Application for a non-material amendment following a grant of planning permission.

Number	
Suffix	
Property name	Merrydown
Address line 1	Kingston Lane
Address line 2	
Address line 3	
Town/city	East Preston
Postcode	BN16 1RP
Description of site location must be completed if postcode is not known:	
Easting (x)	507751
Northing (y)	102607
Description

Increase the height of the proposed structure by 300mm over that approved and increase the depth of the structure by 500mm, retaining distance from high and neighbours boundary as per the original proposal.
Replace barn style doors with Roller garage door to enhance security and accommodate traditional oak knee bracing.

Section 1:50

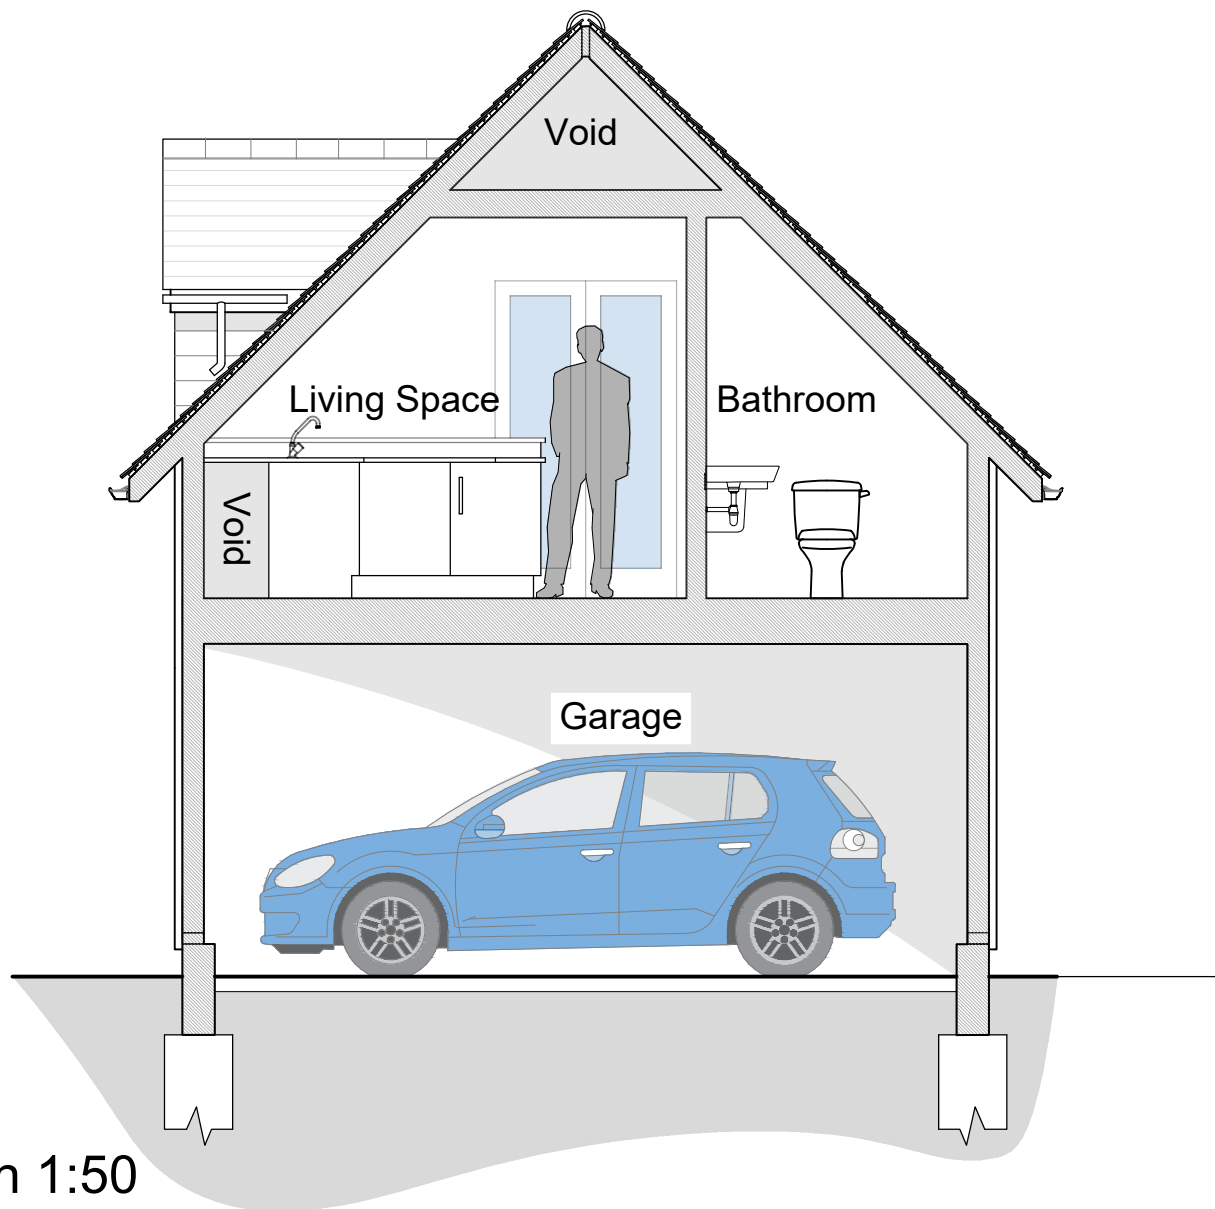
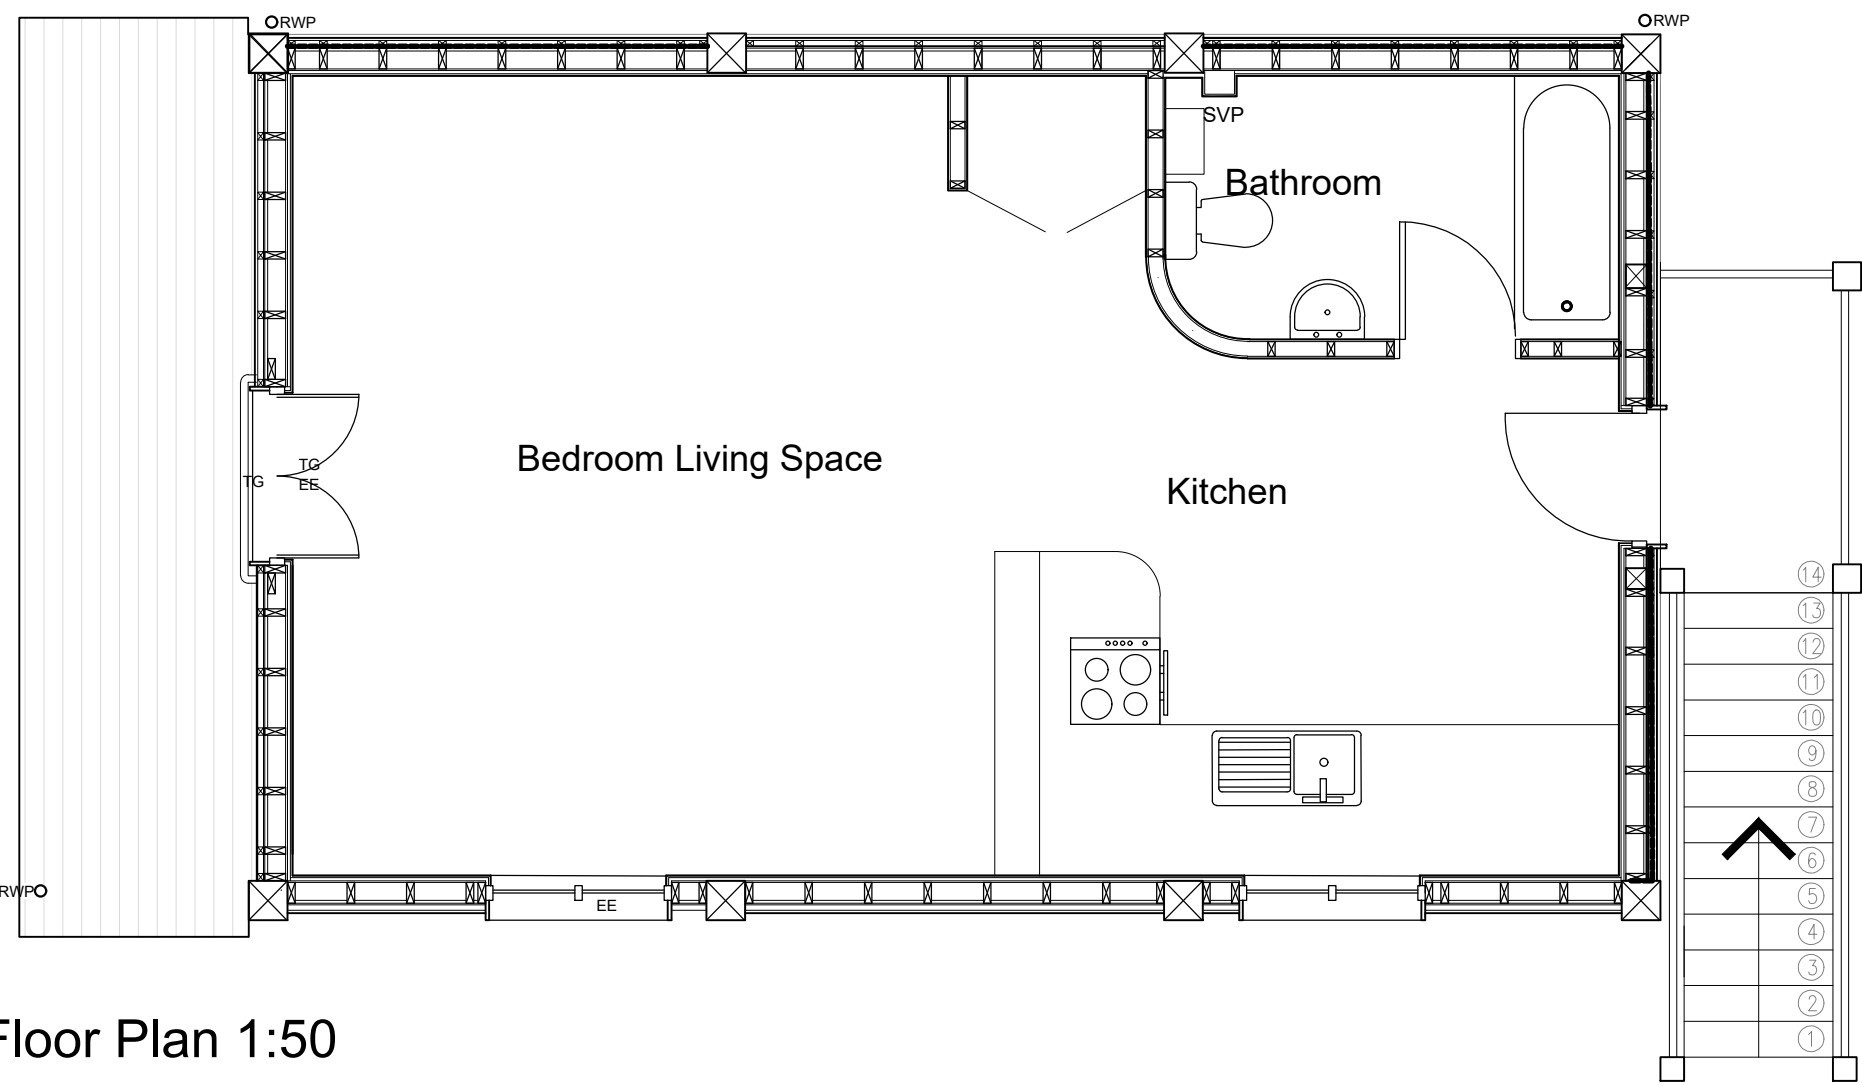
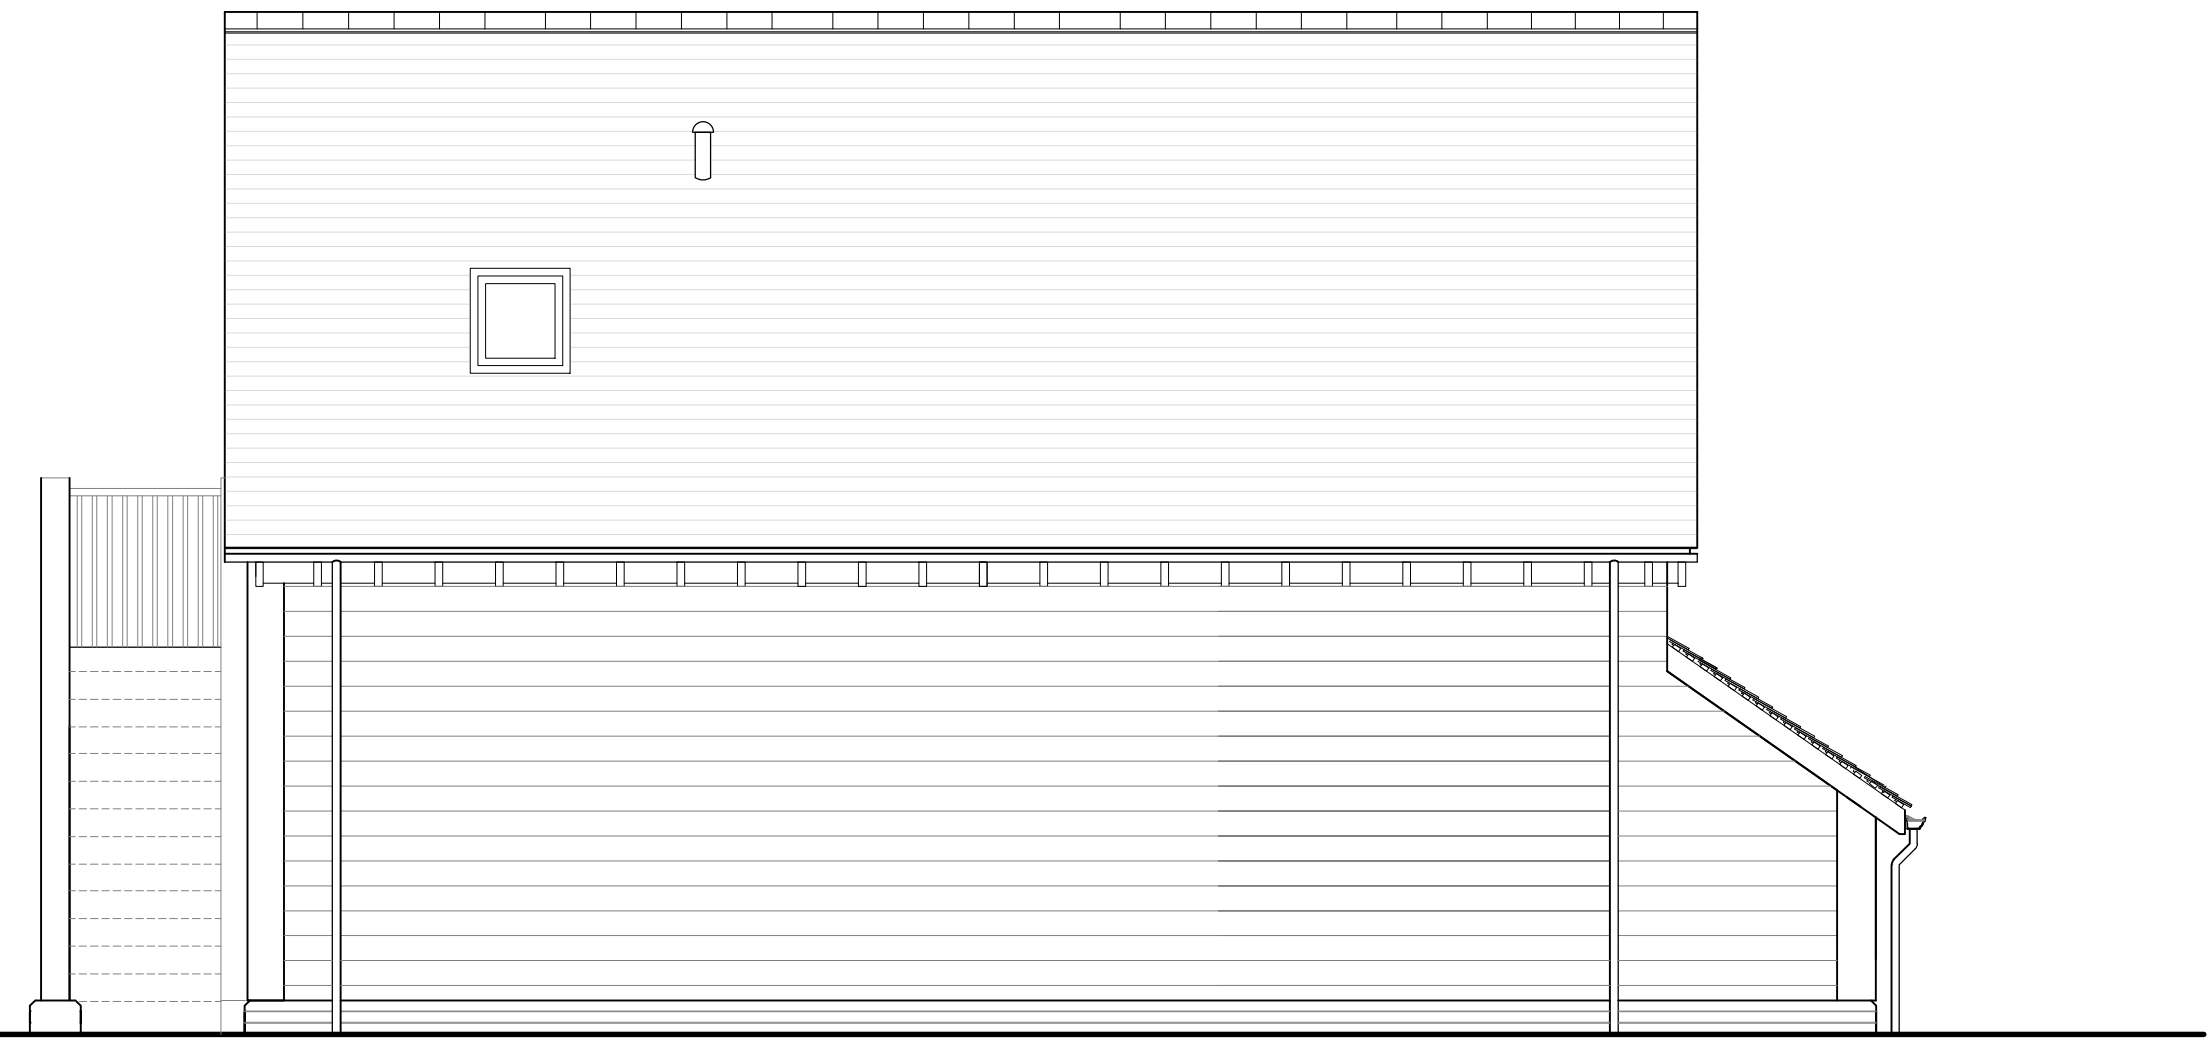
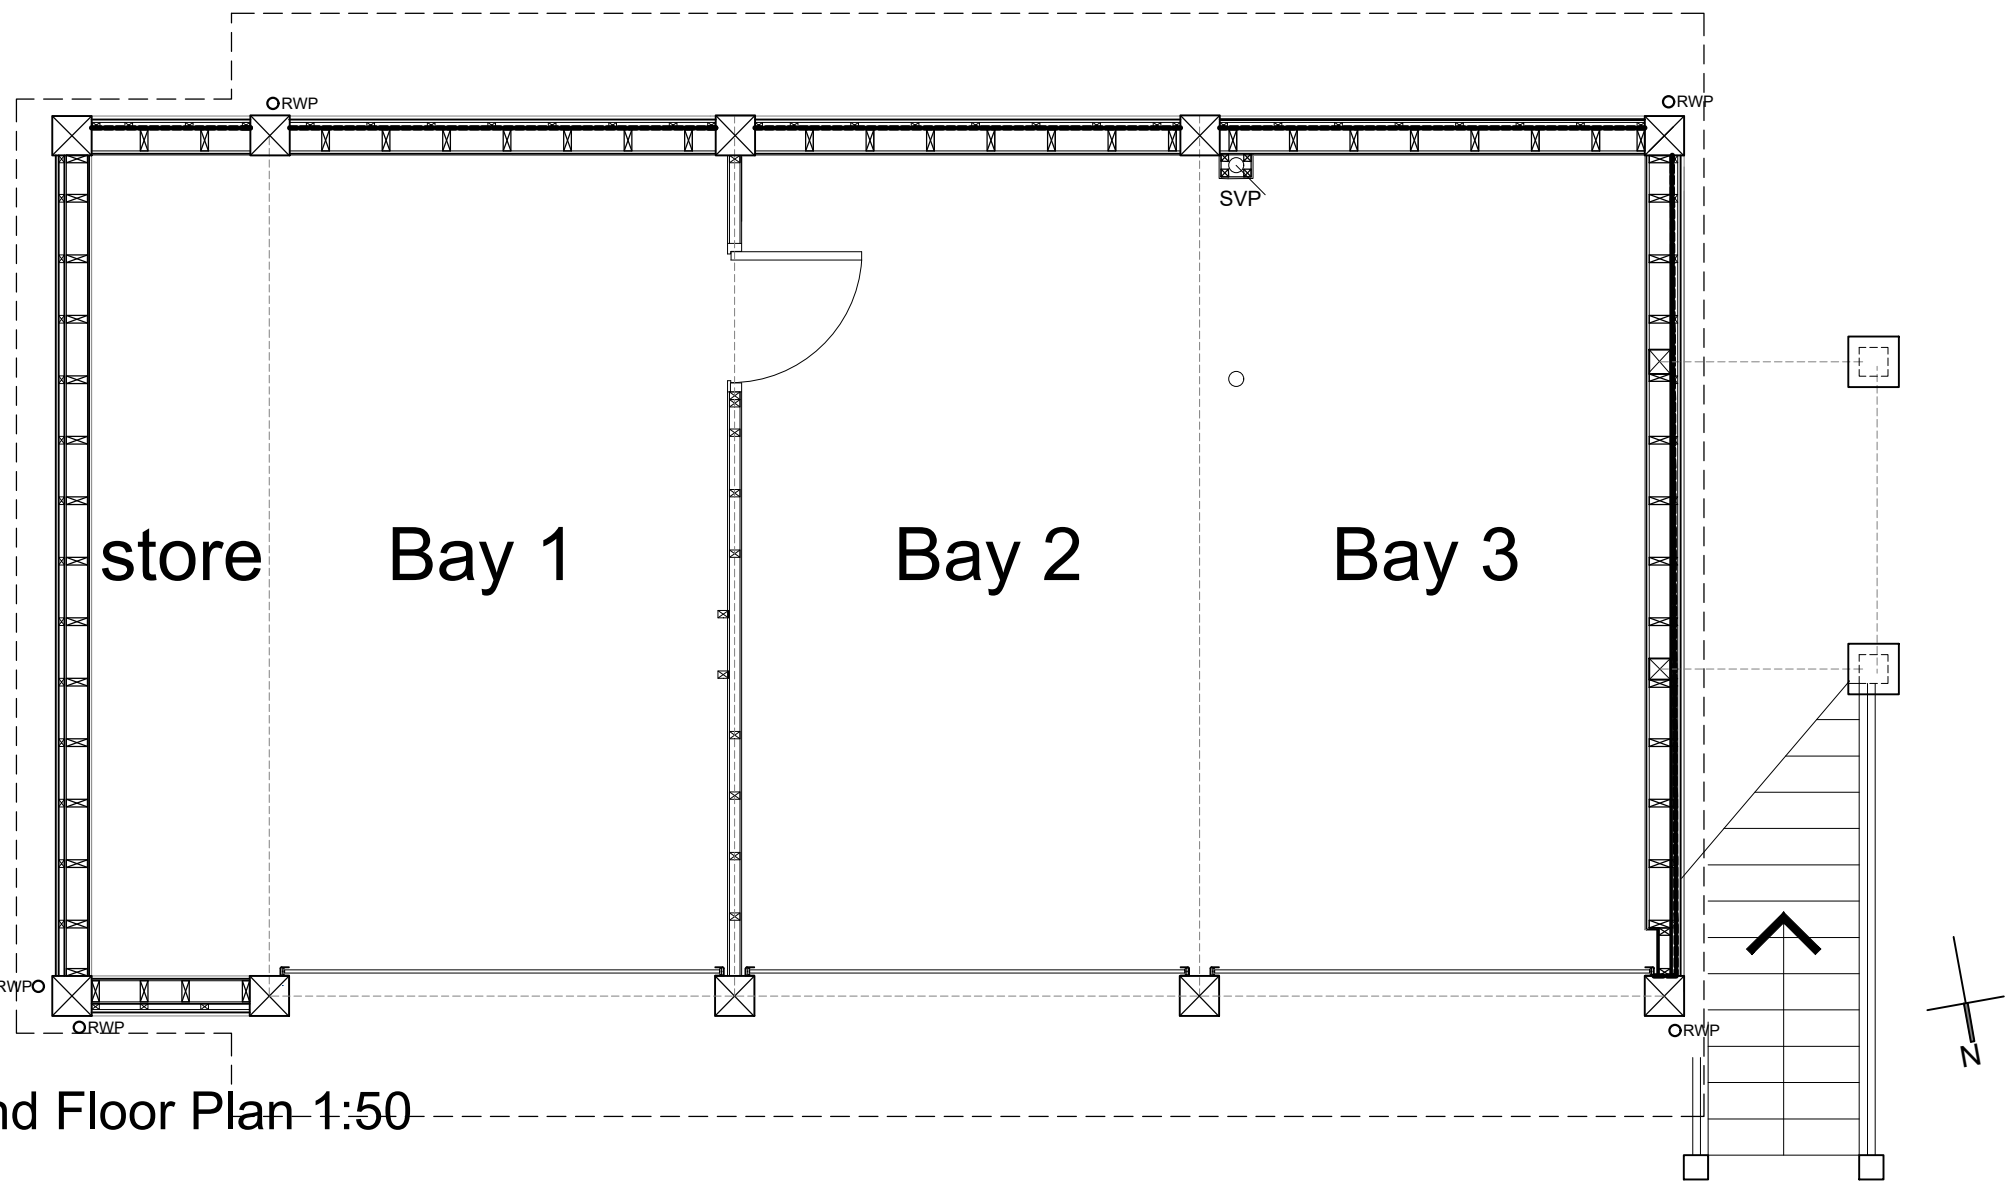
To accommodate a revised roof structure, which will more more cost effective, and to improve the garage depth taking into account an internal framed roller garage door (which will improve security).
